STATE OF NORTH CAROLINA  
DEPARTMENT OF TRANSPORTATION

Subject: **Revision to Permit Application for an Individual Section 404 and Section 401 Water Quality Certification** for the widening of NC 49 from East of NC 73 to East of SR 2630 (Cline Road) in Cabarrus County. Federal Aid Project No. NHS-0049(26), Division 10, TIP No. R-2533CC.

Reference: Individual Permit Application dated September 7, 2010

Please see attached, revised permit drawings and roadway drawings. Revisions to the following drawings are a result of comments received from NCDWQ on November 8, 2010 (see attached e-mail). Revisions have been made to drawings at Site 1 (Permit Drawing Sheets 11, 12, 13 and Roadway Sheets 2-Y and 6), Site 4 (Permit Drawing Sheets 20 and 21), Site 6 (Permit Drawing Sheets 23, 24, 35 and 36), the detail sheet (Permit Drawing Sheet 9, Roadway Sheet 2-J) and the overview sheets of Sites 4 – 9 (Permit Drawing Sheets 18, 19 and Roadway Sheet 11). The revisions in these drawings address the change in size of rip-rap at the outfall of these culverts comprised of two or more barrels from Class "I" to Class "II".

W/LT
Permit Drawing
Sheet 21 of 51
Revised 12/13/10

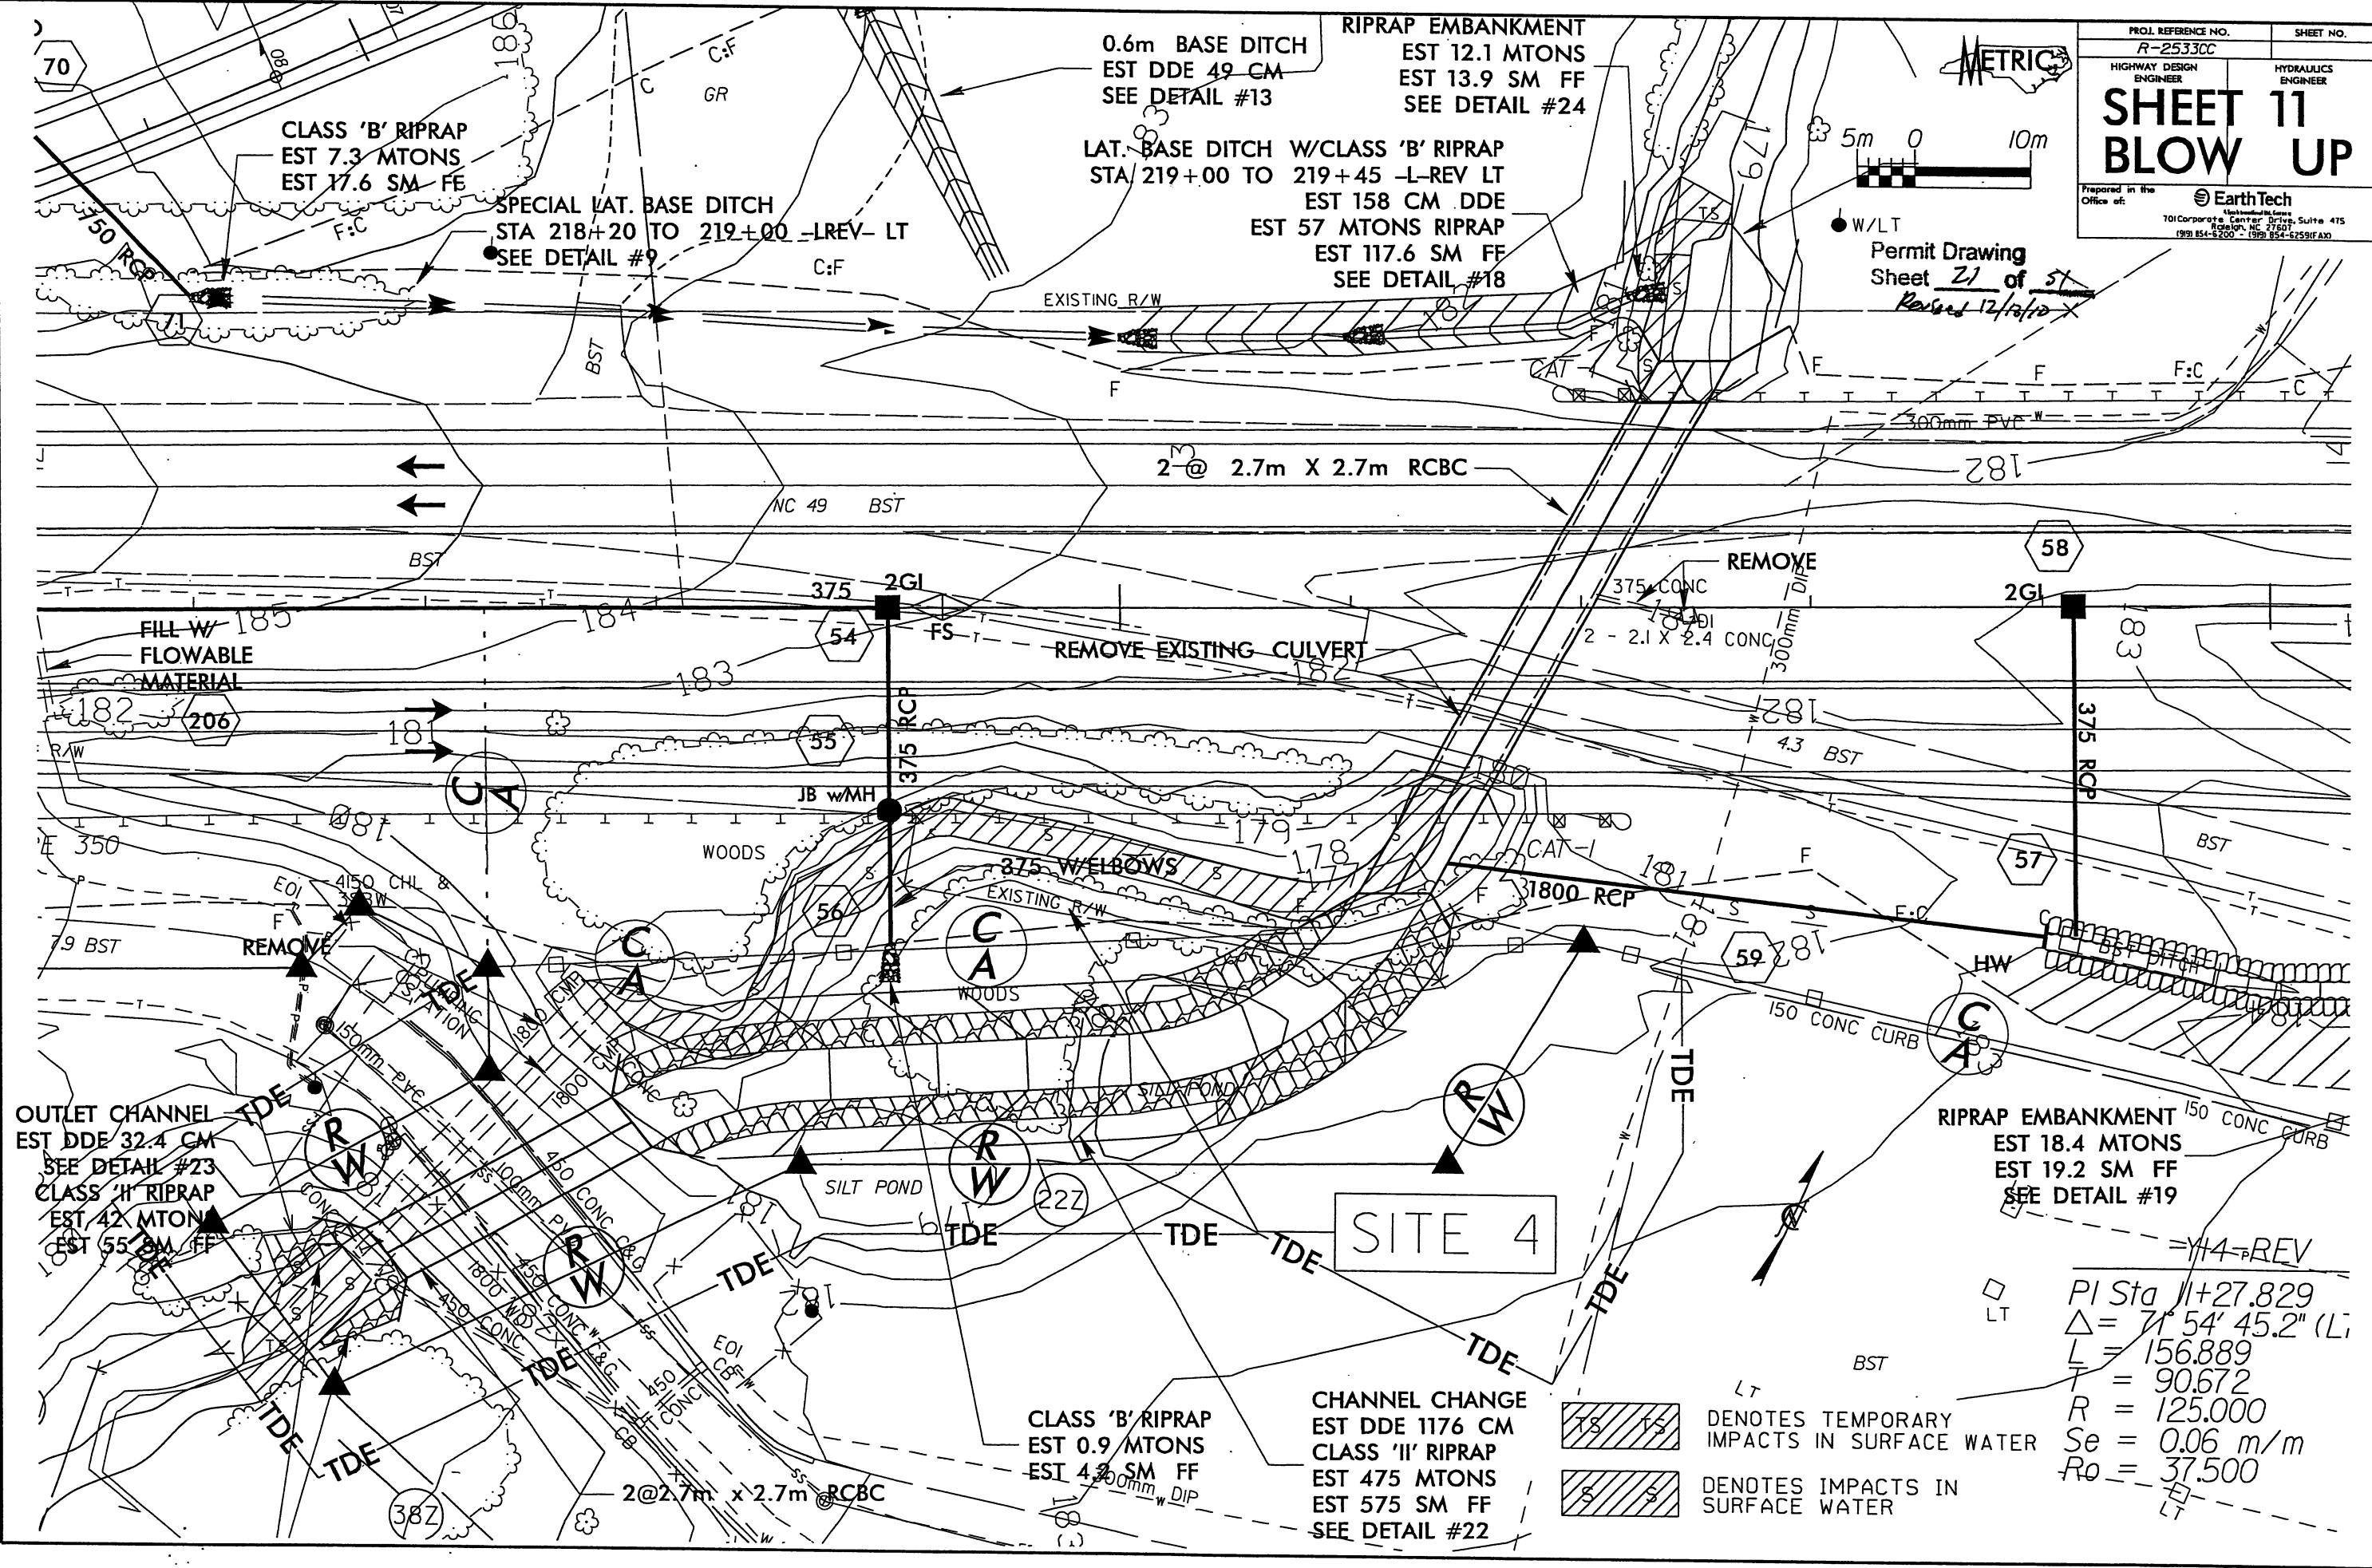
A further revision occurs at Site 4 (Permit Drawing Sheets 18, 20, 21 and Roadway Sheet 11). This revision involves the outfall of a stream into the Site 4 stream. The original design called for the piped Site 7 stream to enter the Site 4 stream at the headwall of the first culvert. A design change calls for the piped Site 7 stream to enter the Site 4 stream approximately 10 feet (3 meters) inside of the first culvert. This design change will help to dissipate flow from the Site 7 stream better than the previous design.

- I have a comment about riprap – it appears that Class I is proposed for most of the ditch outfalls and for bank stabilization. I would recommend the use of larger riprap on those sites that consist of more than a single barrel culvert. Example: Site 8 is a small intermittent stream and Class I is proposed for bank stabilization. That seems to make sense. Site 5 (outlet channel – Detail 23) proposes Class I riprap and it’s a double barrel culvert conveying a perennial stream. This is a little more confusing to me. Seems like with the larger streams, there is more opportunity for the riprap to move into the stream, at which point it will typically have to be manually removed.

SEE DITCH NOTE #2
 SEE DITCH NOTE #7

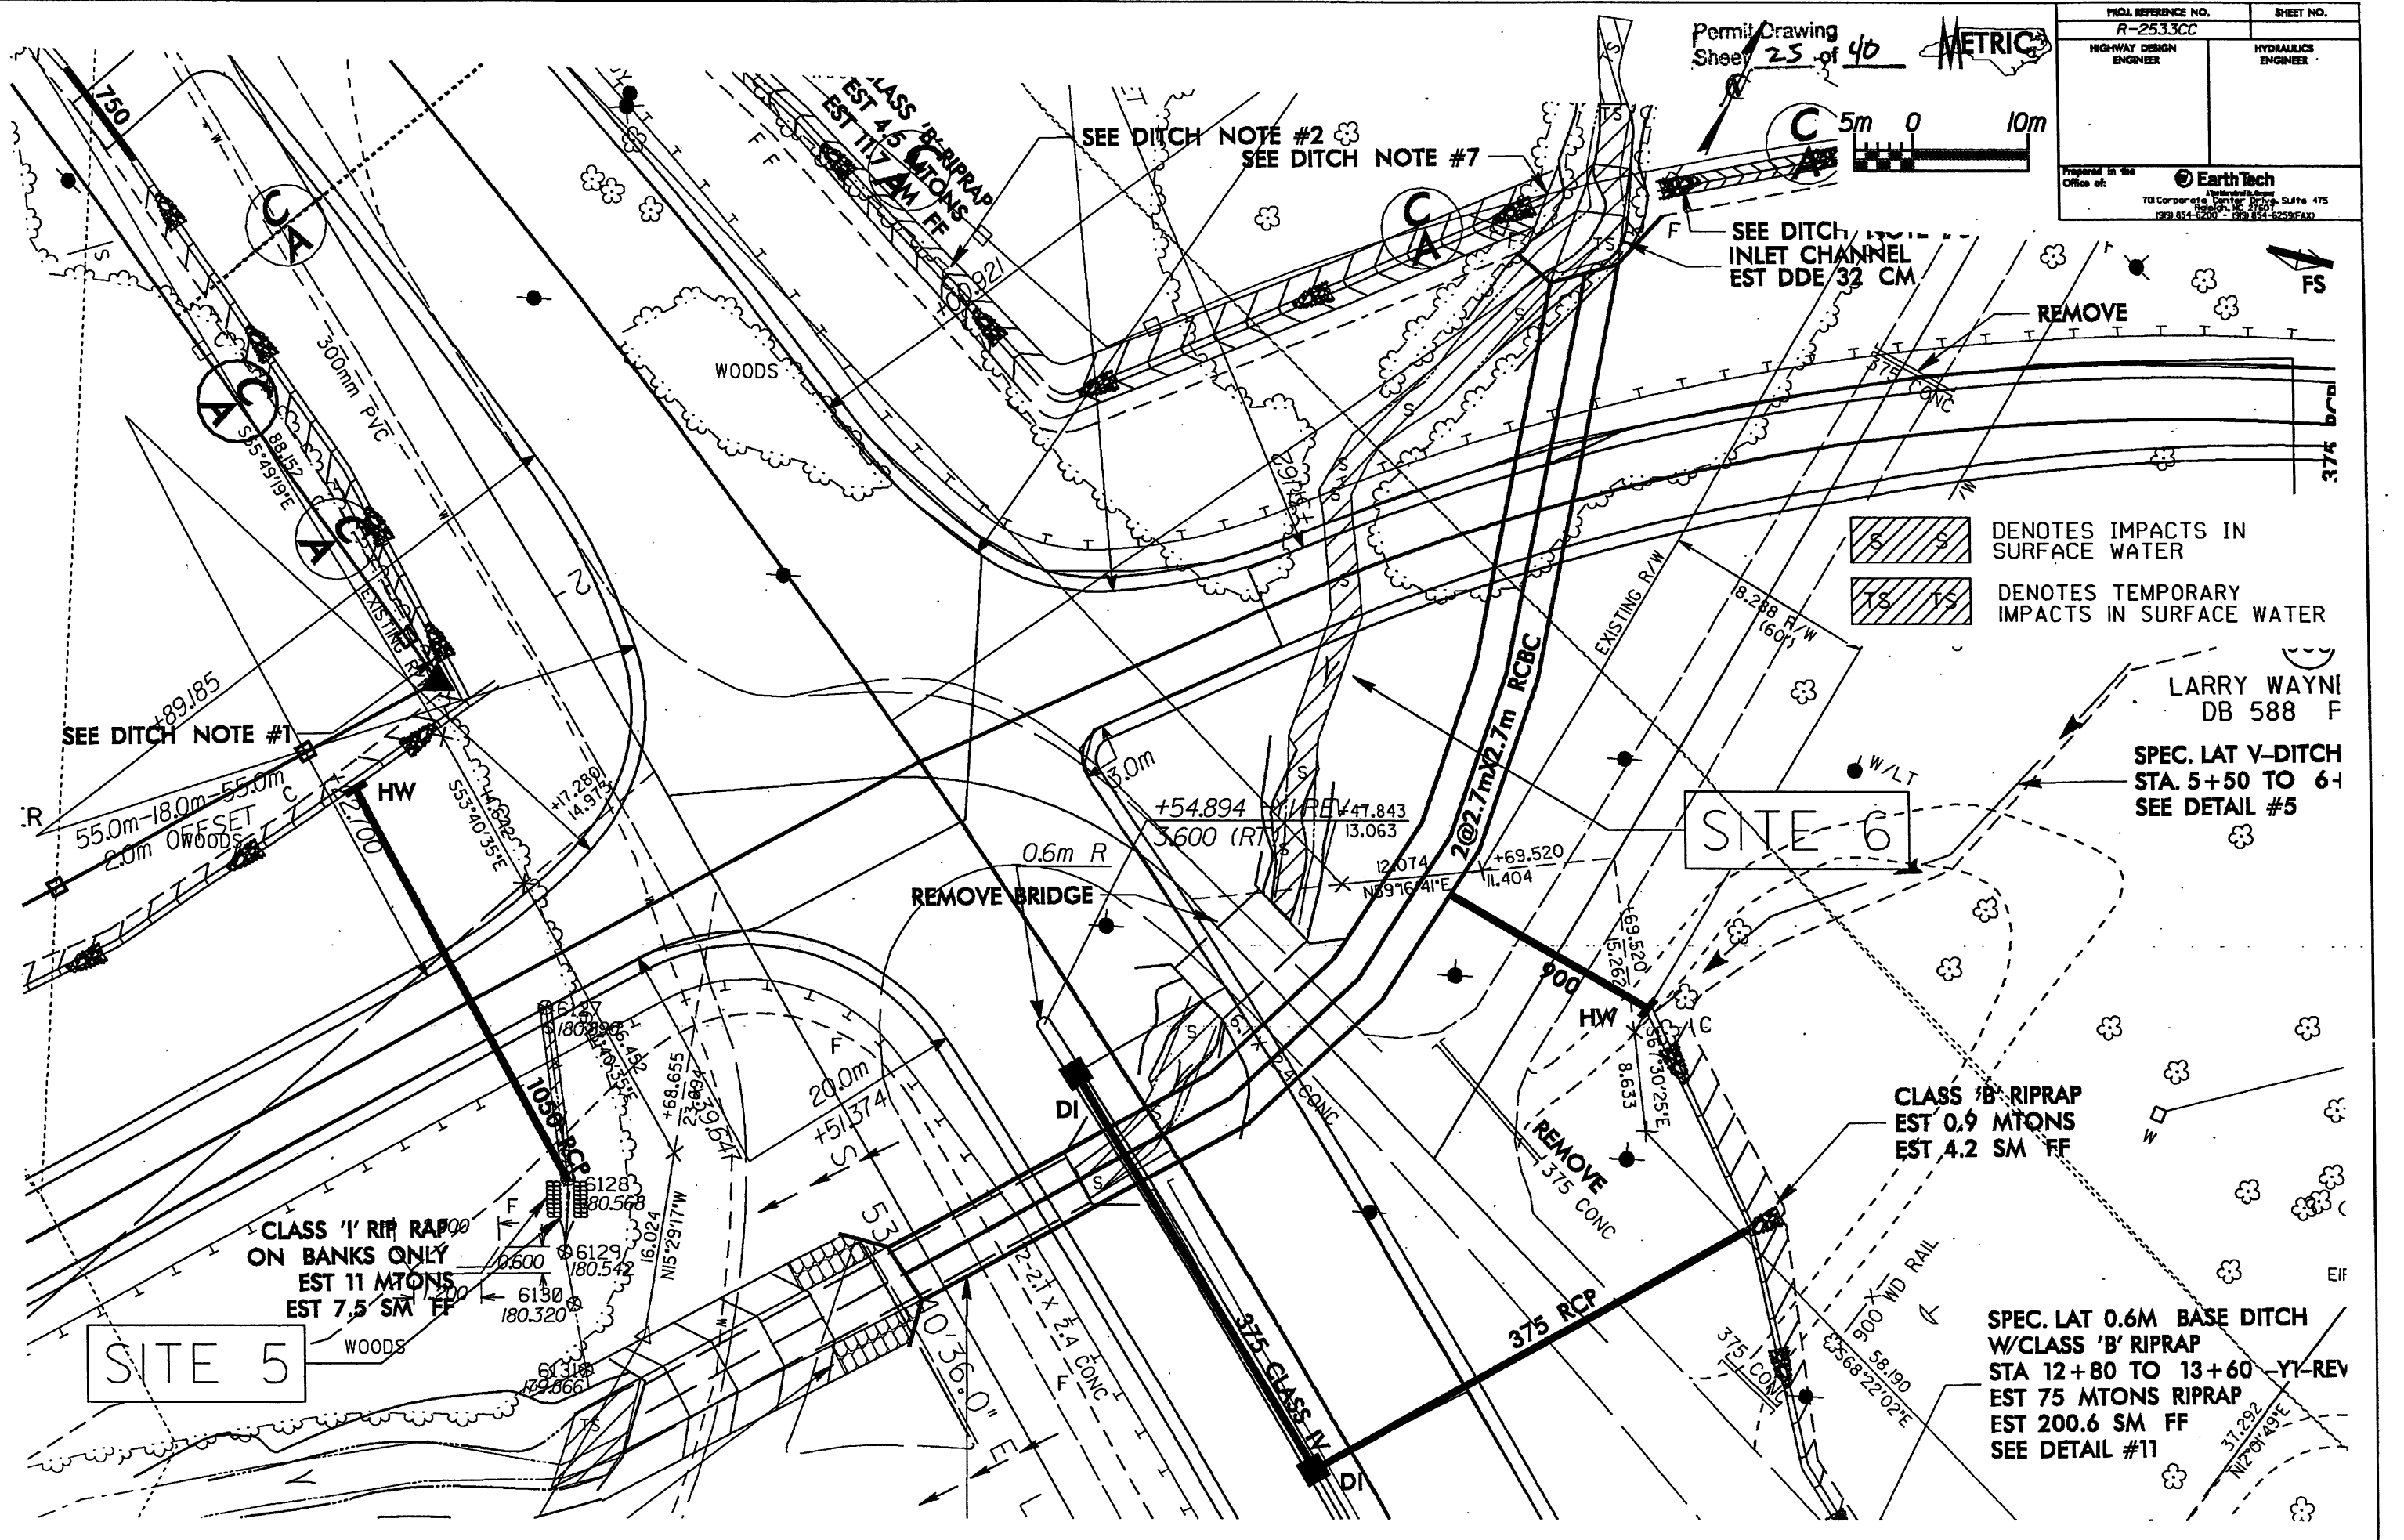
- Some of the permit sheets refer to “ditch notes”, specifically ditch notes “1”, “7” and “8”. I could not locate these “notes” on the drawings. Can you please let me know where they are or provide them if they were not included.
